Applicant: Oxford University Development Ltd

Proposal: Discharge of Condition 4 (contamination remediation strategy) of
21/03150/REM

Remediation Plan - Western Half of Plot C

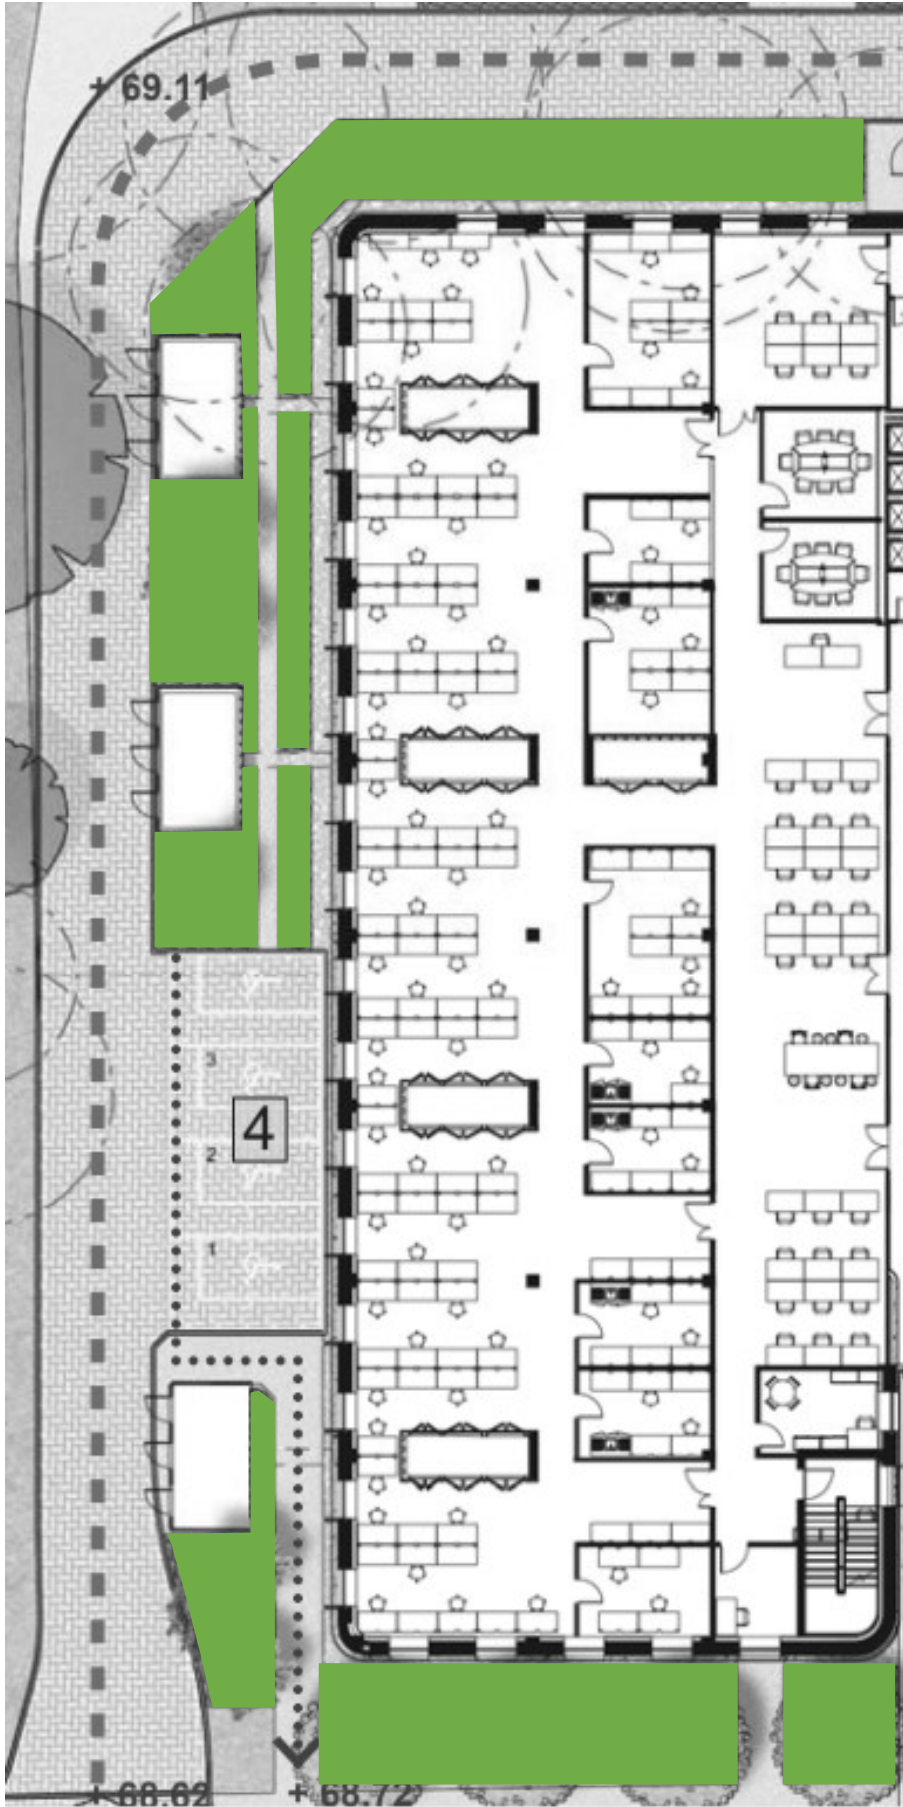
Landscape – the depth of the capping topsoil should be increased to 400mm to take account of 15% settlement and the deeper hand digging required for containerised shrubs where contaminants may be brought to the surface if the depth is only 300mm. No further comments have been received following the receipt of information demonstrating this depth.

A contamination report and additional plans have been submitted with the application (which show an increased depth of topsoil). These are of an acceptable standard and therefore meet the requirements of condition 4 of application 21/03150/REM.

Details provided in document titled: C15633.1 (Plot C exploratory hole locations), C15633 (Remediation Plan – Western Half of Plot C – showing 400mm topsoil) and Contamination report (with the clean imported topsoil at 400mm in accordance with C15633).
